**Subject: International Indoor Soccer Arena, 1311 Cuesta Arriba CT. NE,  
Albuquerque, New Mexico**

**Re: Responses to comment letter dated August 18, 2011**

**Re: International Indoor Soccer Area, 1311 Cuesta Arriba Ct. NE, Grading Plan  
Engineer's Stamp date 7-14-11 (D16/D00X)**

GRADING AND DRAINAGE PLAN

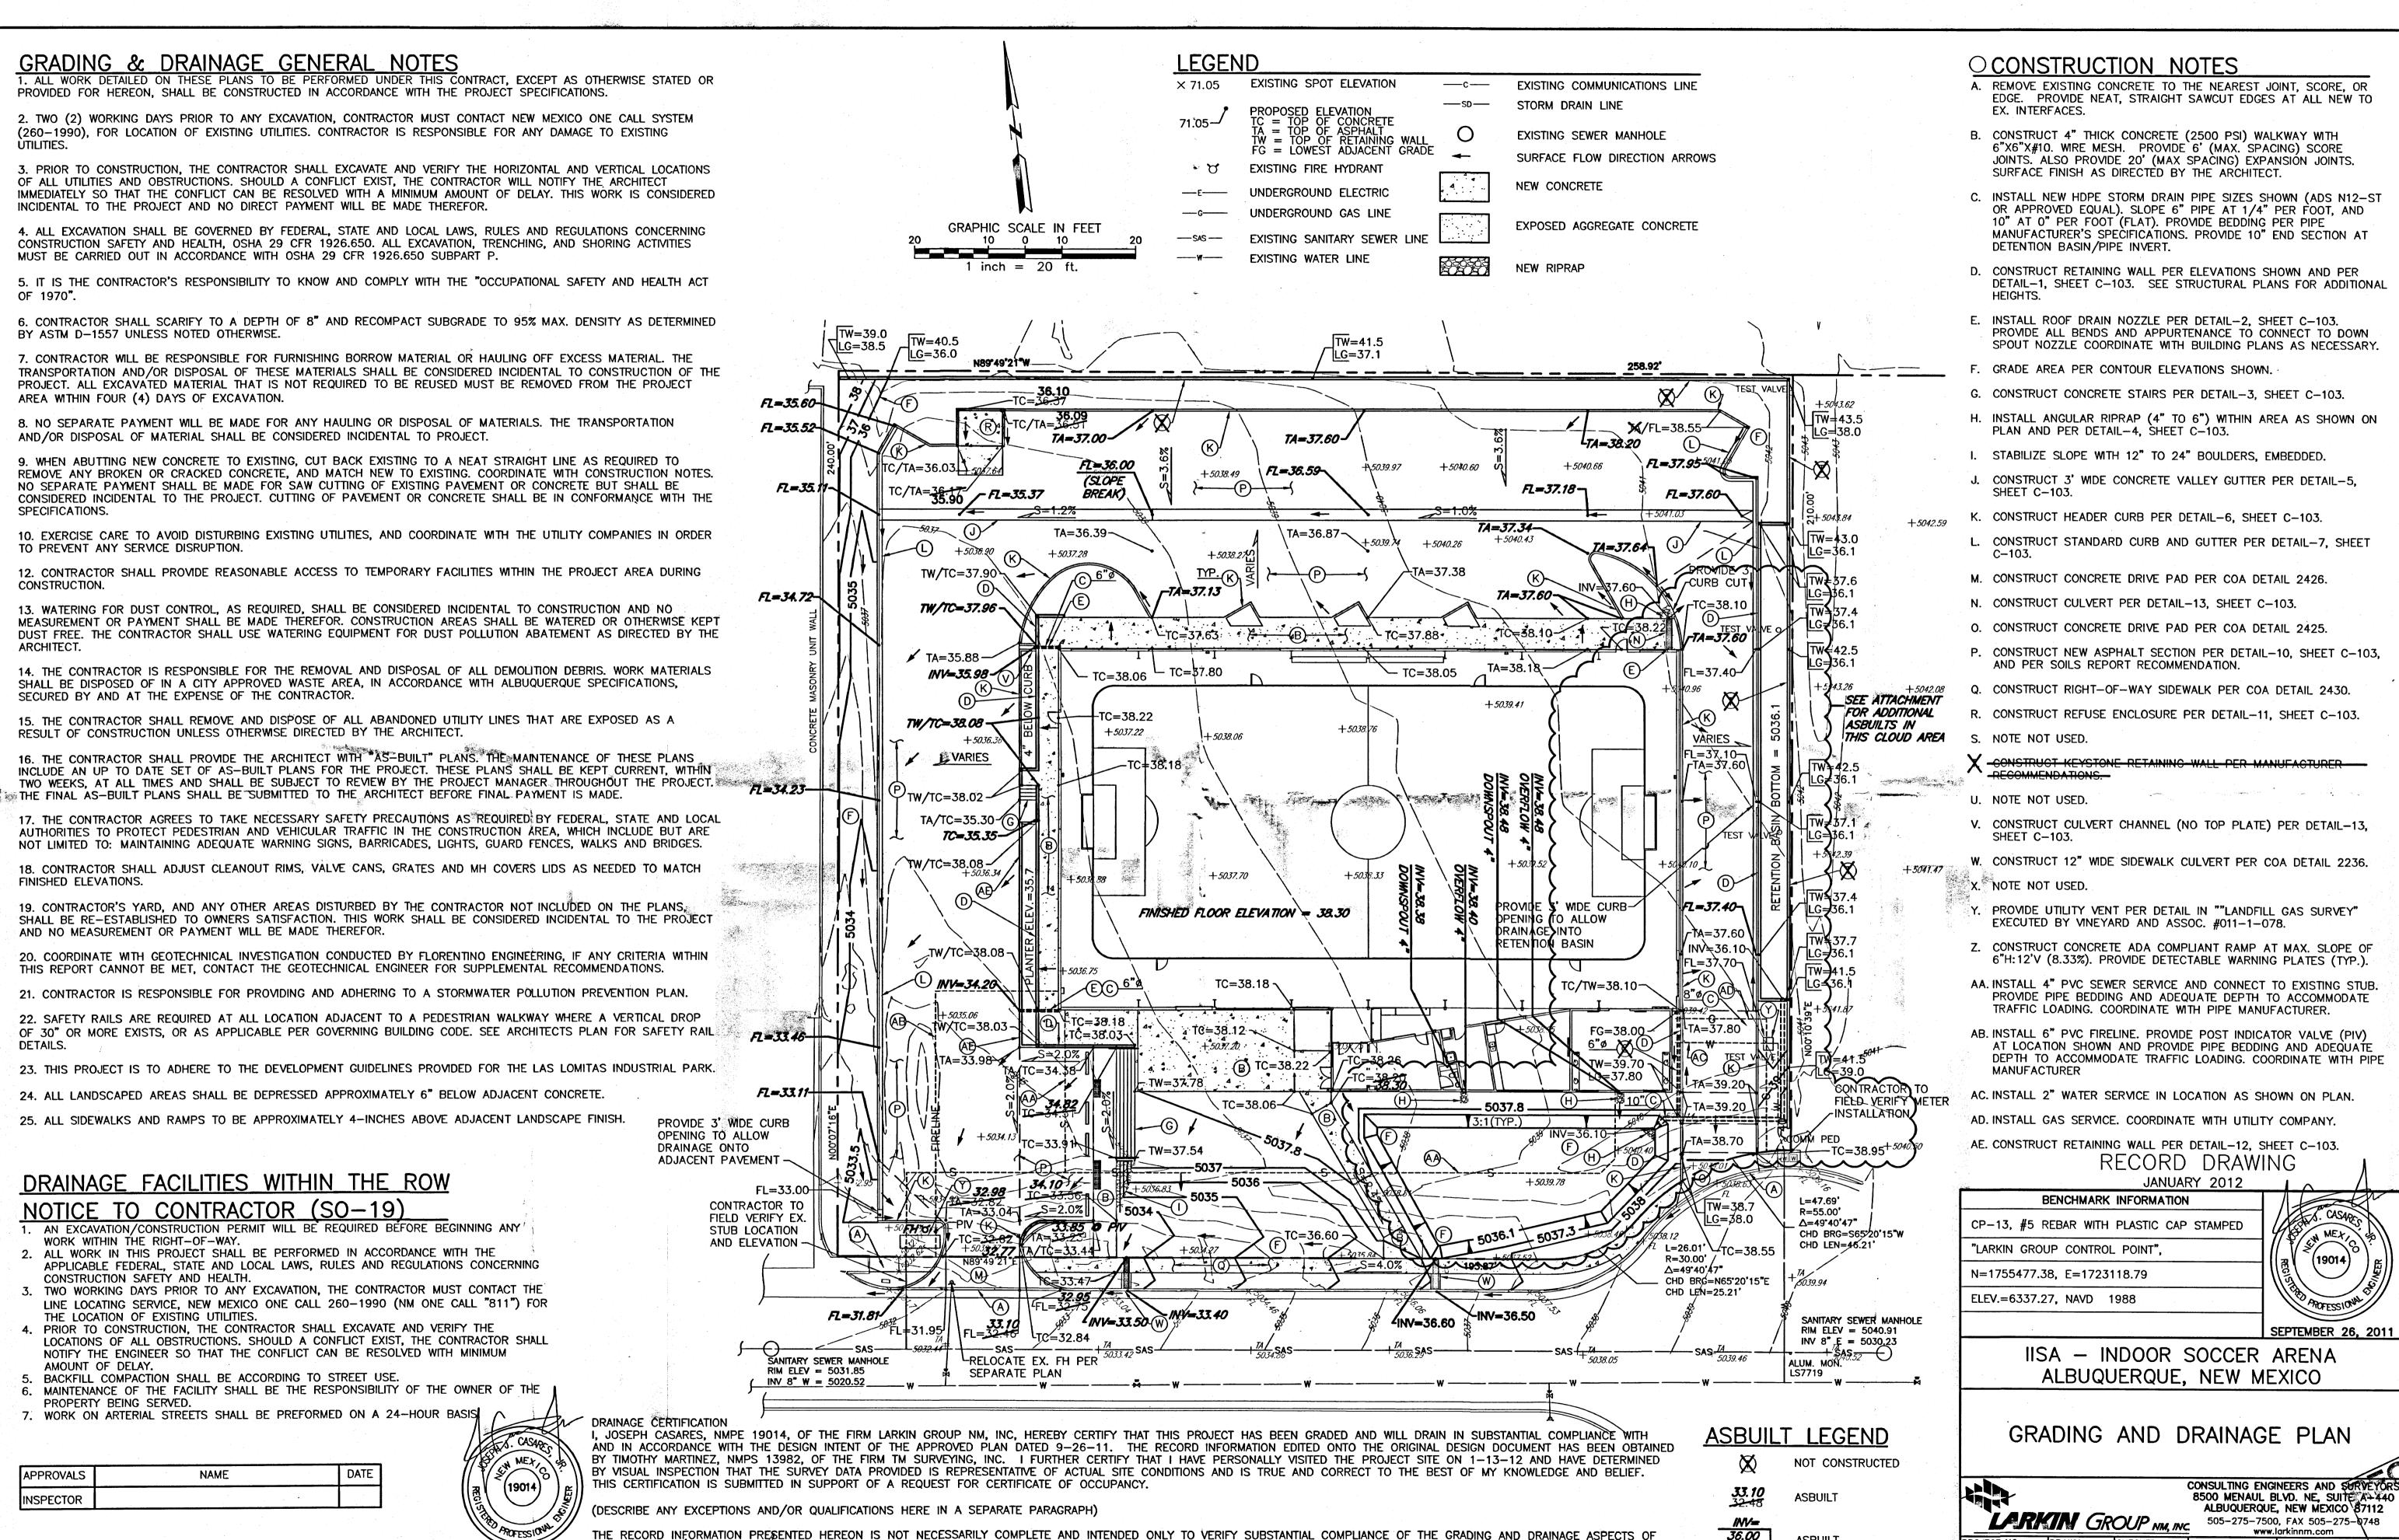
- Provide City Drainage file number and a copy of the plan where the allowable discharged is shown. *he has files*
  - Provide the total discharge from the site and make sure that it does not exceed the allowable discharge.

- Provide SO-19 construction notes and signature block for the construction of the sidewalk culvert.
  - Please use the attached revised copy of the sidewalk culvert on your plans.

- Extend the sidewalk culvert plate to the back of the curb.
  - Also use the orifice equation for sizing the sidewalk culvert.
  - Thicken the boundaries for drainage Section A, B, & C.

- Please provide spot elevations for the trash enclosure.
  - Please show parking spaces and handicap parking area.
  - Please show the door locations for the building.

- ✓ The landscaping along the westerly property line is draining out over the sidewalk. Please provide a sidewalk culvert, or route the runoff onto the paving area and out to the street through the entrance.
- ✓ See attached markups for additional comments.
- ✓ Hydrology is requesting that proposed landscape areas be depressed to retain/infiltrate the rain that falls on them.

- SO-19 construction notes and signature block now provided on sheet C-101.
- Sidewalk culverts within the ROW are now referenced to COA Standard Detail 2236, latest edition. On-site culverts are referenced to detail-13 shown on sheet C-103.

- Sidewalk culvert plate within the ROW has been extended to back of curb.
- Culverts calculations shown on sheet C-100 are now analyzed with the orifice equation.

- Boundaries shown on sheet C-100 for all areas are now thickened.
- Spot elevations for refuse area are now provided.

- Parking spaces and HC parking are now shown on sheet C-102.
- All door locations to the outside are now shown on sheet C-101.
- The runoff within the westerly landscaped area is now routed to the on-site pavement through a three foot curb cut (sheet C-101).
- All mark-ups and comments have been addressed.
- General note #24 on sheet C-101 now indicate all landscaped areas to be depressed approximately six inches

## DRAINAGE AREA PRE-DEVELOPMENT

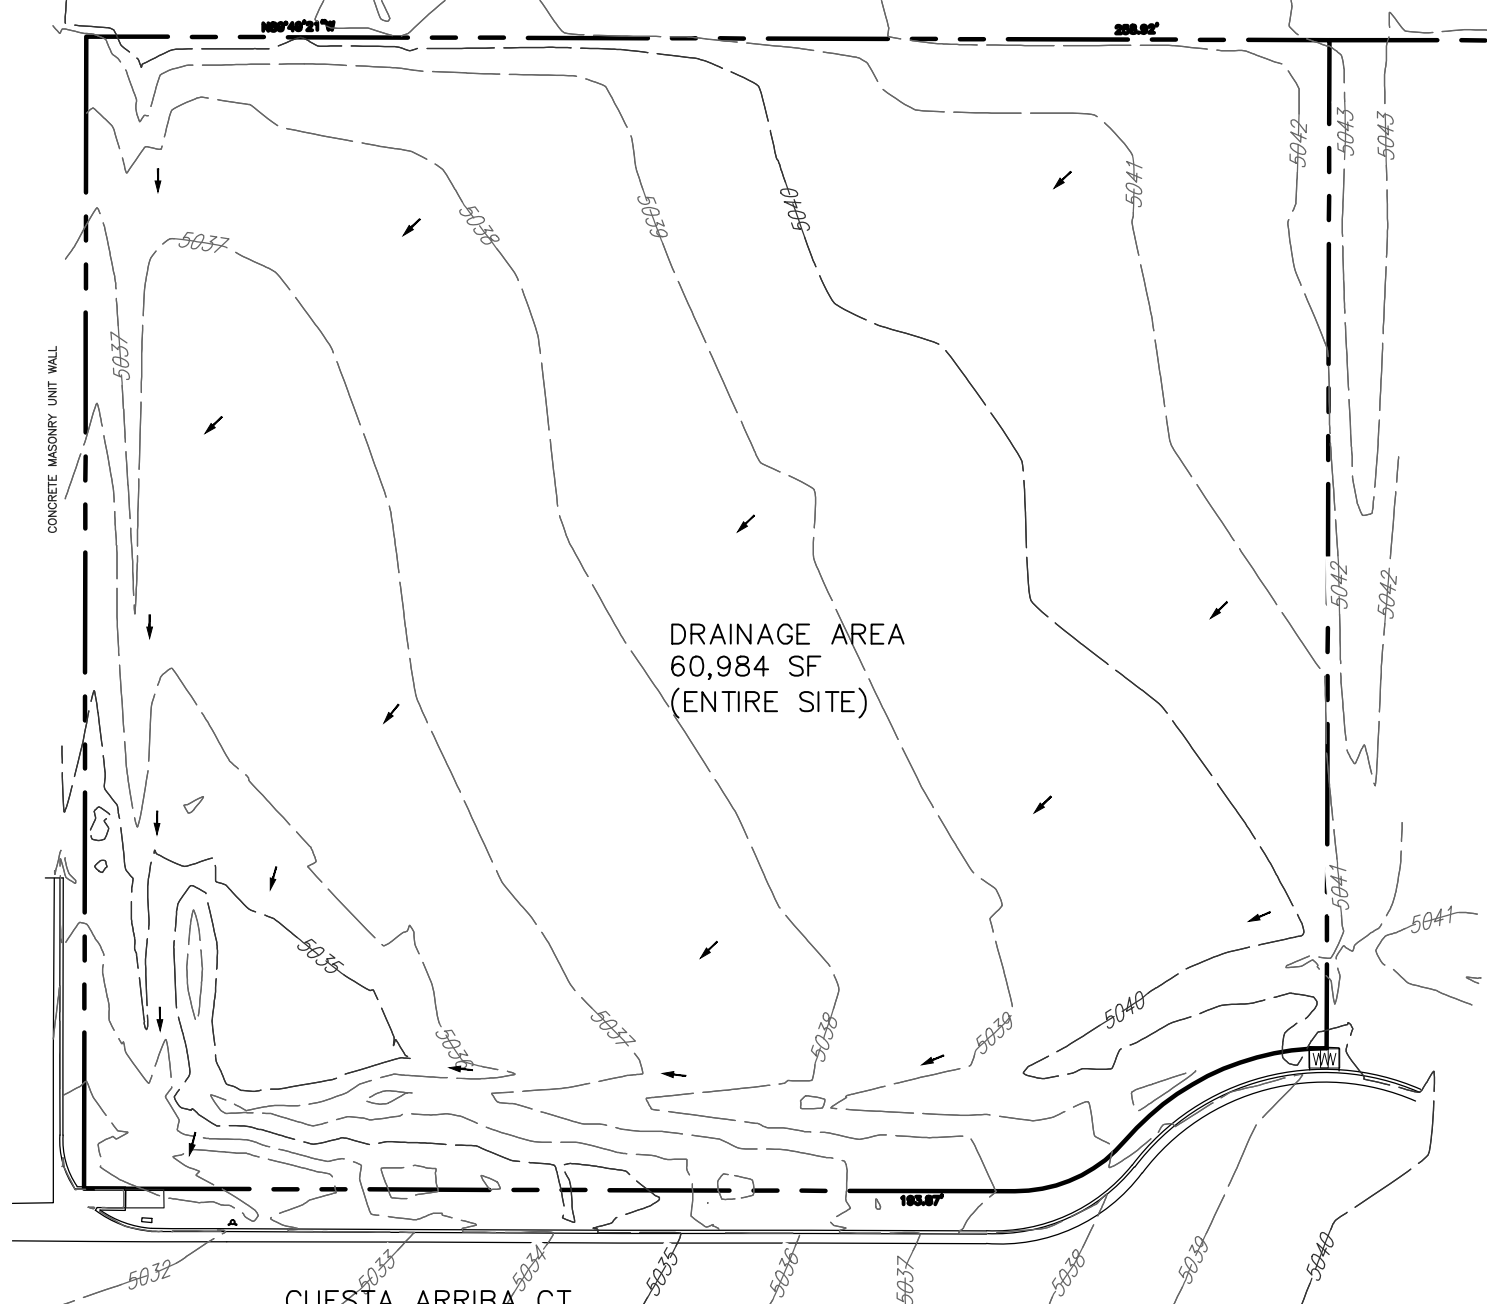
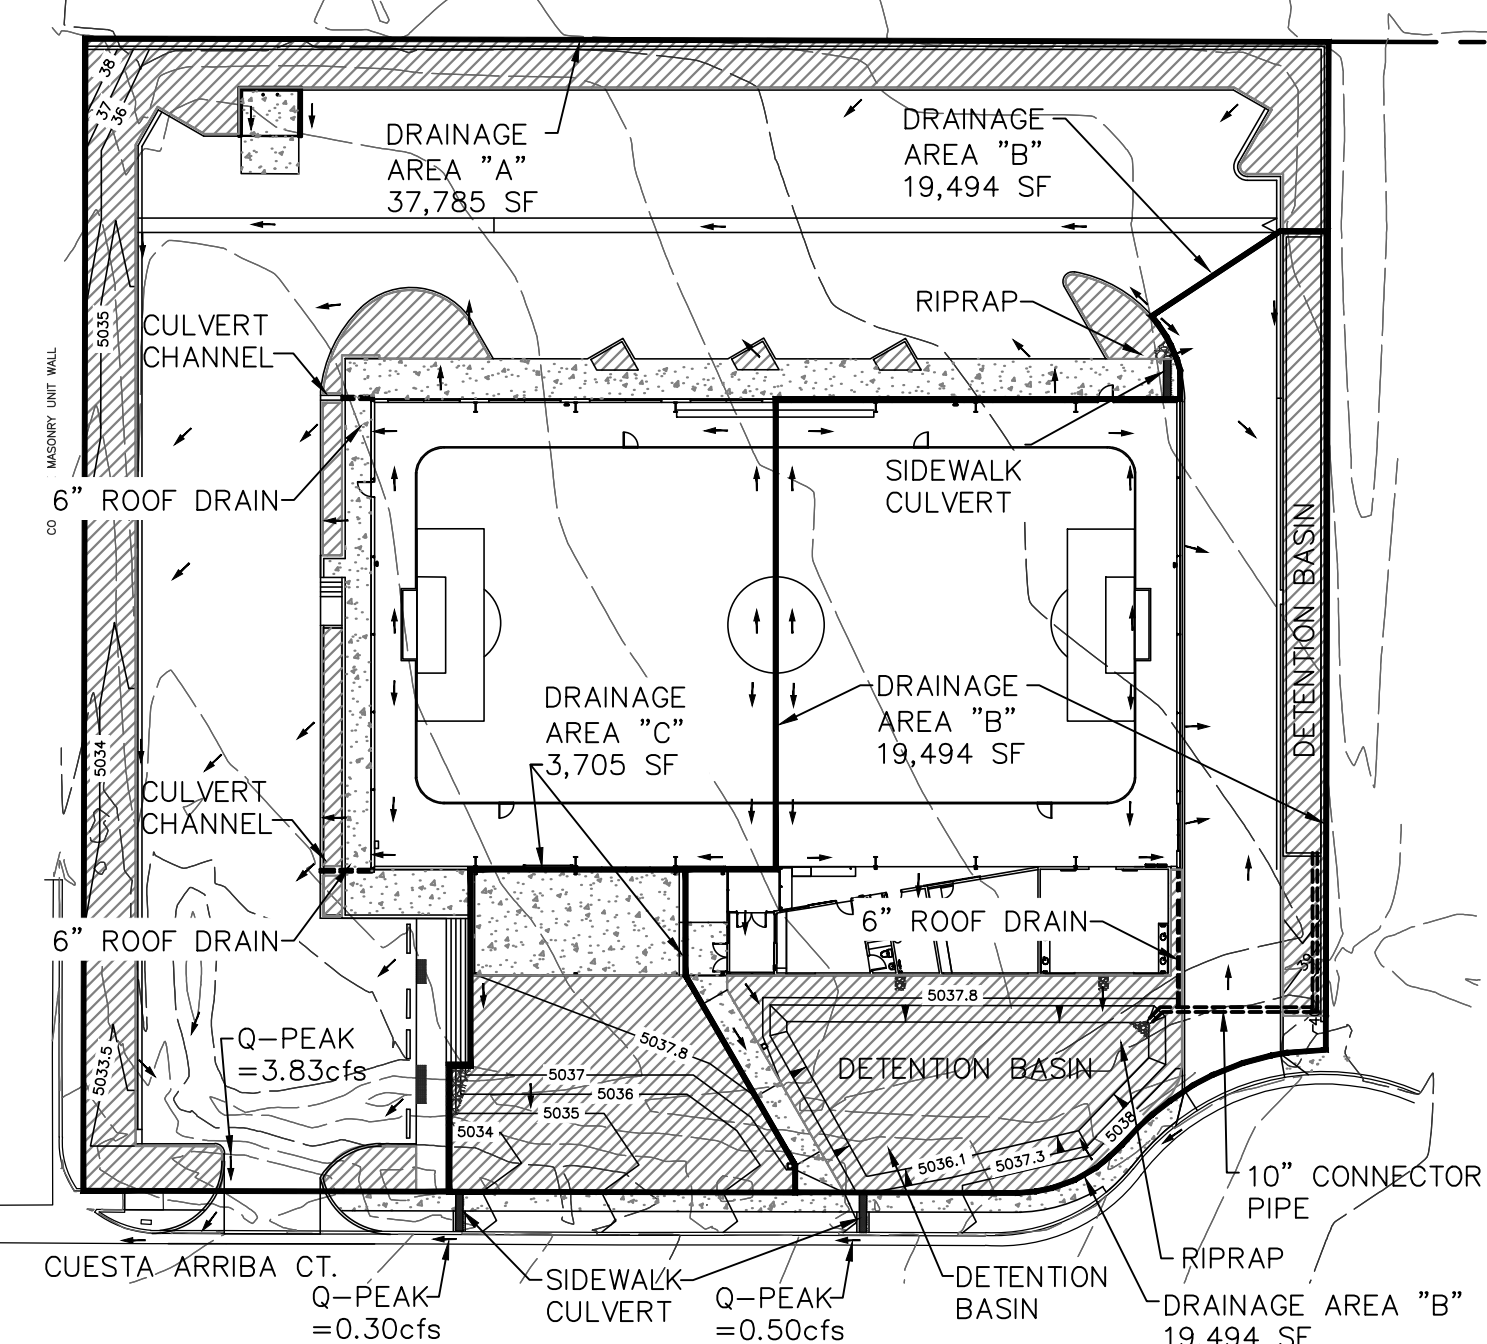
- Is the address 1311 or 1321 Cuesta Arriba Ct., NE.
  - Please provide calculations for the runoff analysis (if AHYMO was used please submit your input and summary output files)

- SO-19 approval now requested.
- The address is 1311 Cuesta Arriba Ct. NE
- The site was analyzed using the COA DPM process for watersheds 40 acres and less. A spreadsheet has been set up to facilitate calculations. All input parameters are shown on sheet C-100, table 1. Results of spreadsheet calculations are also shown on sheet C-100.

- City drainage file (D-16/D002C) now provided on sheet C-100 in sections I, III and X.
- The total discharge (4.79 cfs) is now provided on sheet C-100 in sections I and X.
